Submission for Job: #6010 SSD 6010 - One Residential Building (Student Accommodation) within Darling Drive Plot

**SSD 6010 - One Residential Building (Student Accommodation) within Darling Drive Plot**

**Submission by:**

**29 July 2013**

21st June, 2pm

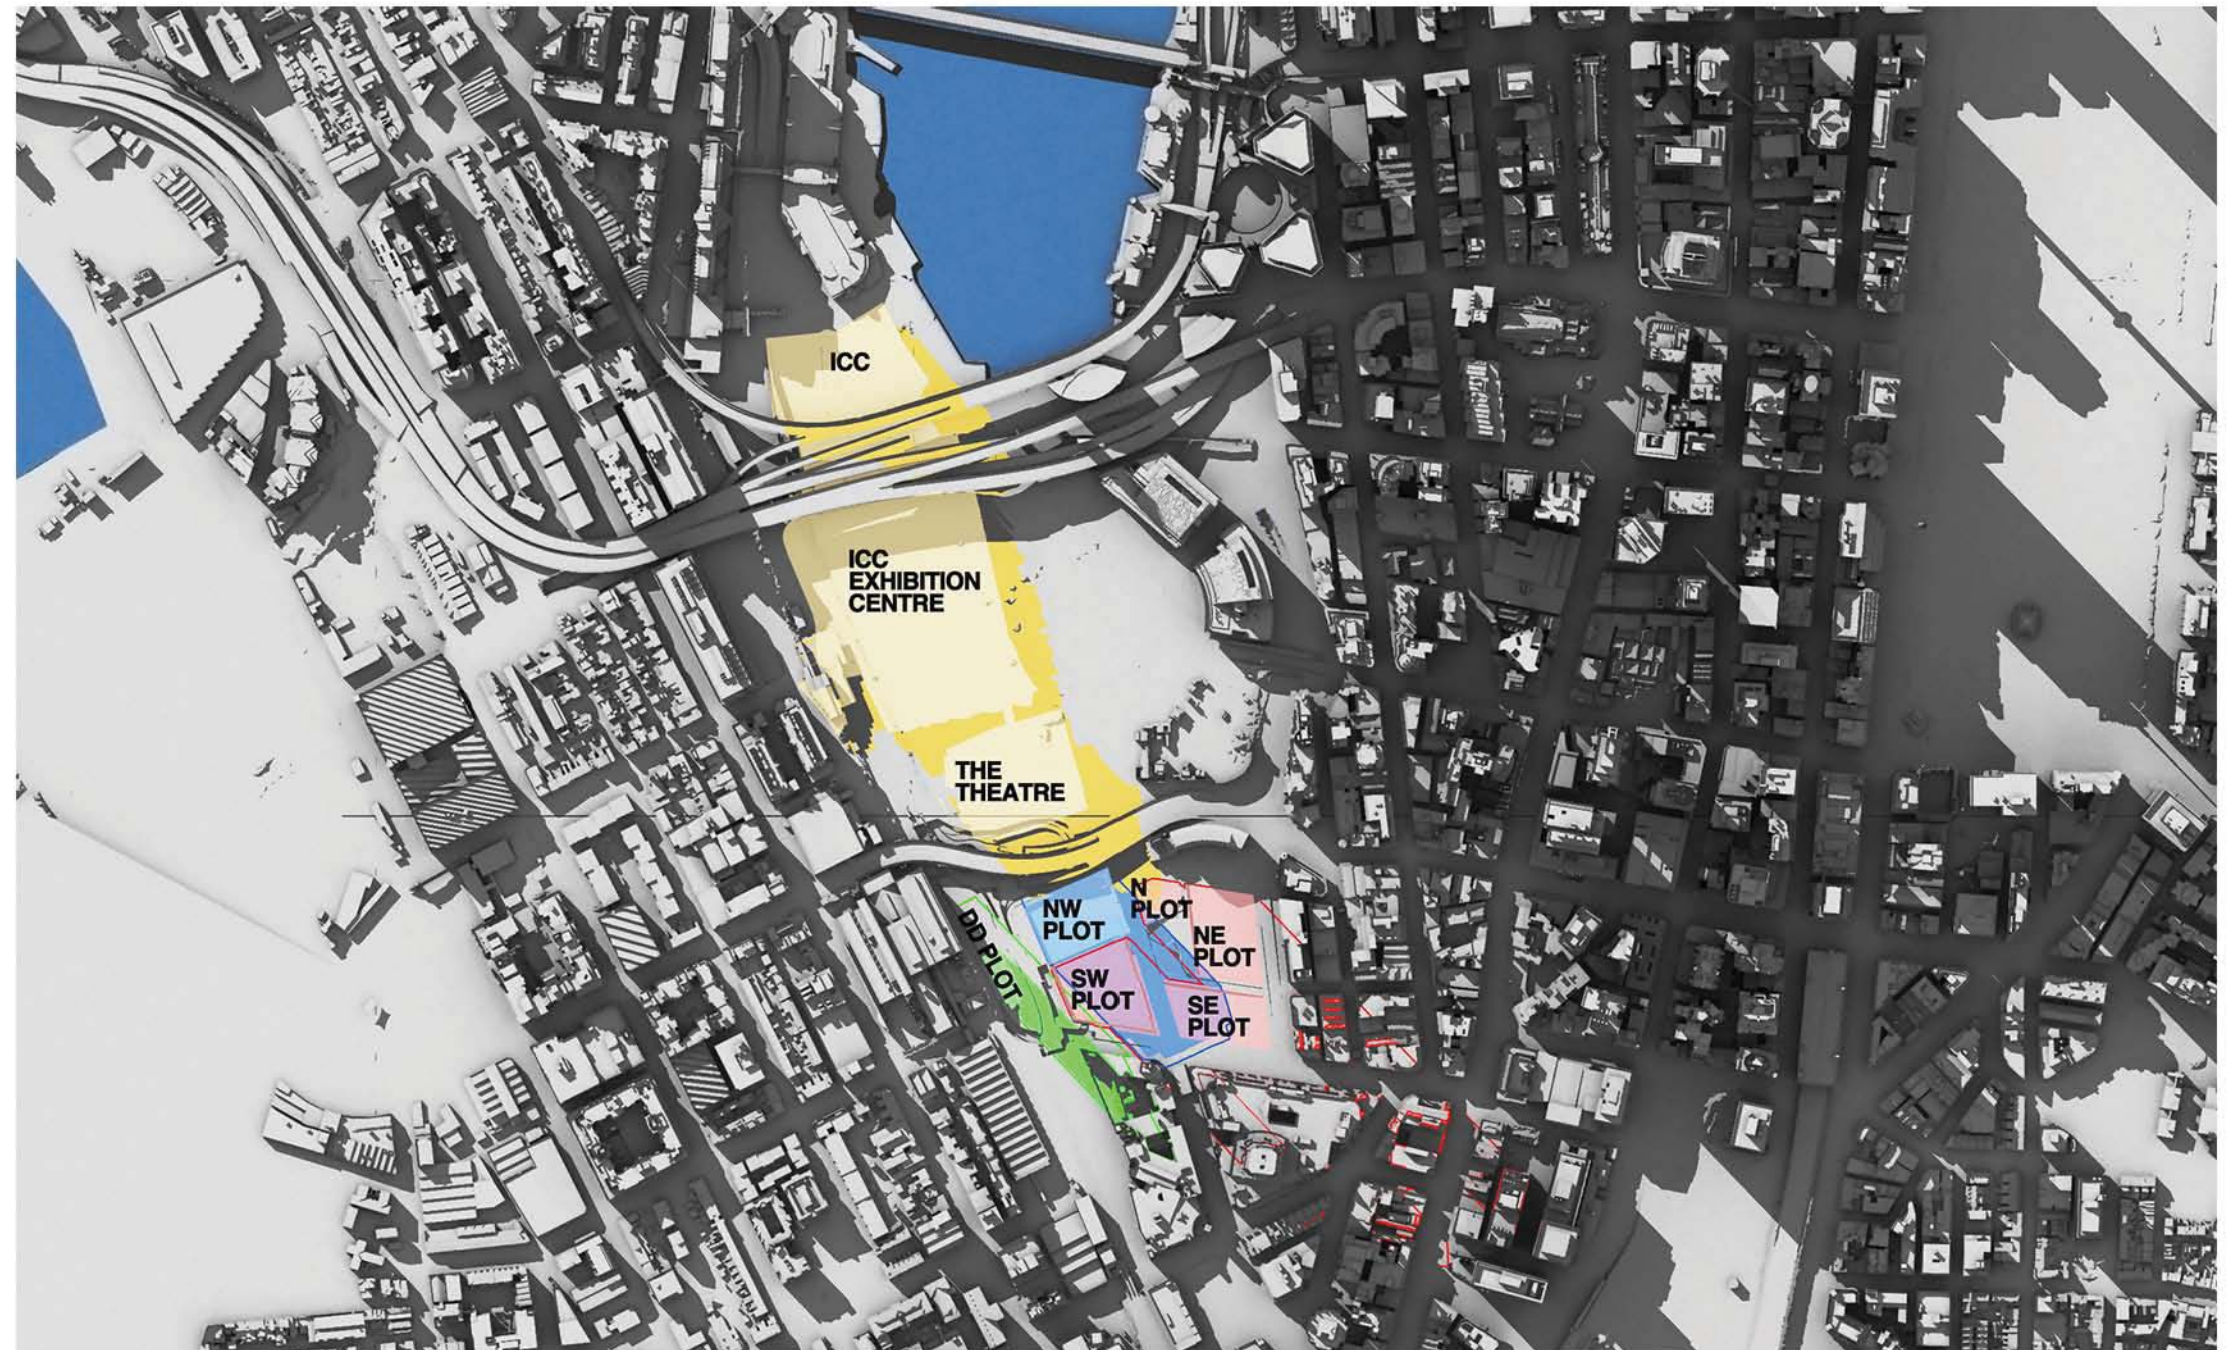
At 1pm the existing shadowing has been substantially, although not entirely, removed. However, overshadowing of lower levels of the west façade by the concept proposal parameter plan shadows for the N,NE and SE plots has already started.

By 2pm the existing shadowing has been totally removed. However, overshadowing of the west façade by the SSDA4 and SSDA5 buildings has appeared and risen further up the west façade than the concept proposal parameter plan shadows for the N,NE and SE plots, which is still present.

SHADOW DIAGRAMS: PERSPECTIVE, SHOWING THE PEAK, WINTER SOLSTICE

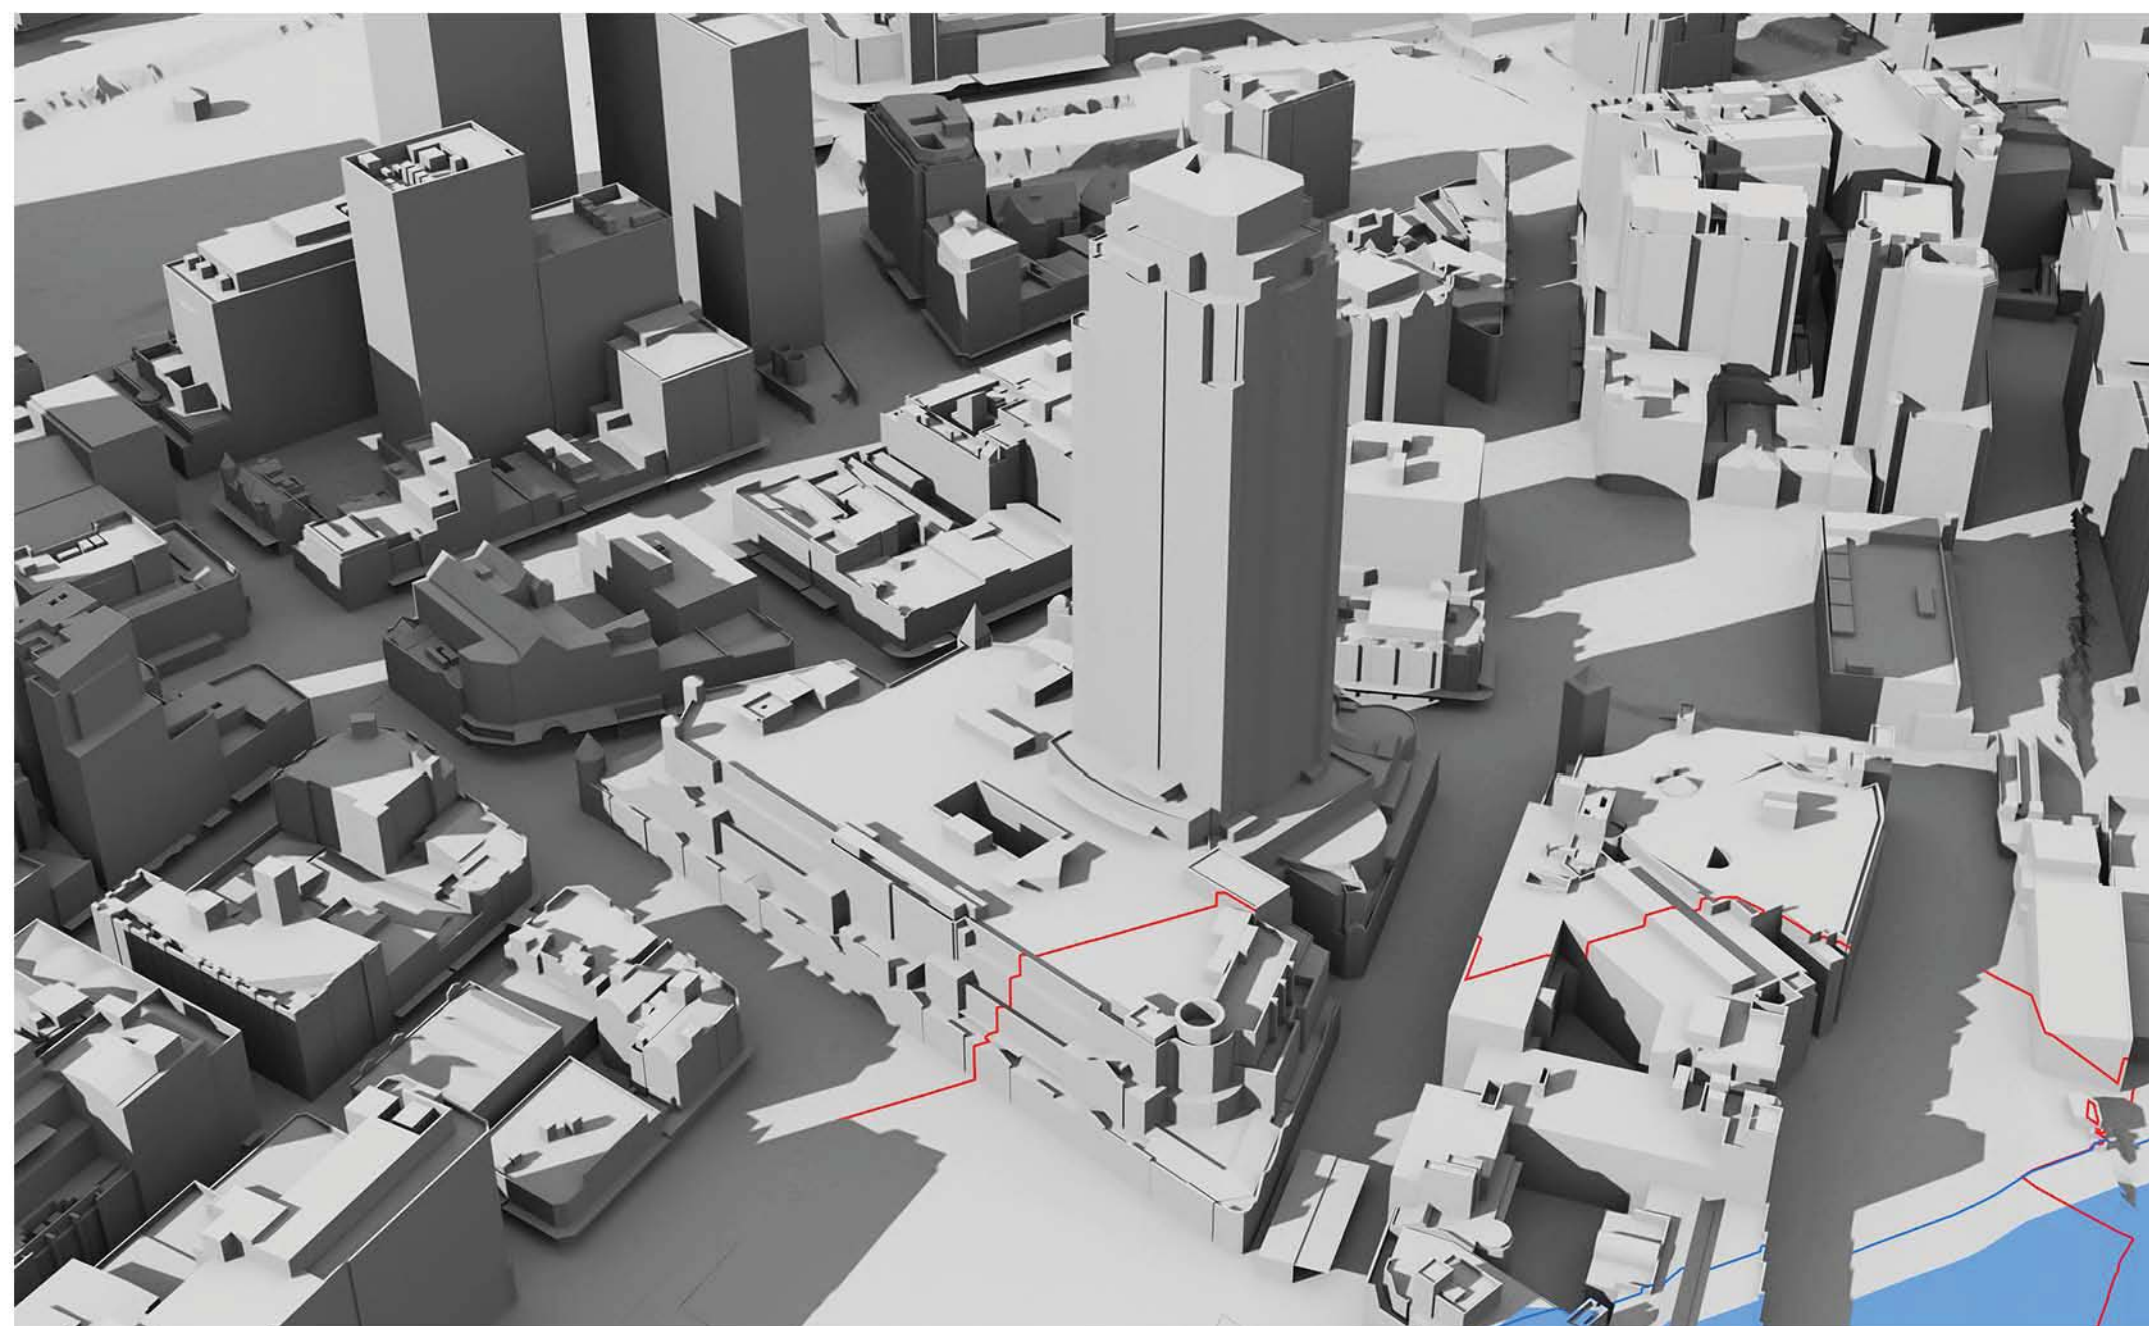
## 6. Existing shadowing of the west façade of The Peak on 21 June

The proponent provides diagrams but fails to discuss the existing shadowing of the west façade of The Peak.

We refer to the shadow diagrams in SSD5878, Appendix H. Supplementary Design Report, Section 6. Amendments, Winter solstice - 22 June. This is not 21 June, but there would be no noticeable difference.

At 9am, 10am and 11am the west façade is totally in shadow due to other parts of The Peak building itself.

At 12pm there is still substantial existing shadowing on the west façade caused by the irregular shape of the west facade.

At 1pm the existing shadowing has been substantially removed, but not totally removed.

It can be concluded that some single aspect apartments on the west façade and some south-west dual aspect corner apartments currently receive less than 2 hours direct sunlight to habitable rooms and 50% of the private open space between 9am and 3pm on 21 June.

By 2pm the existing shadowing has been totally removed, but that is too late to achieve two hours of direct sunlight before 3pm.
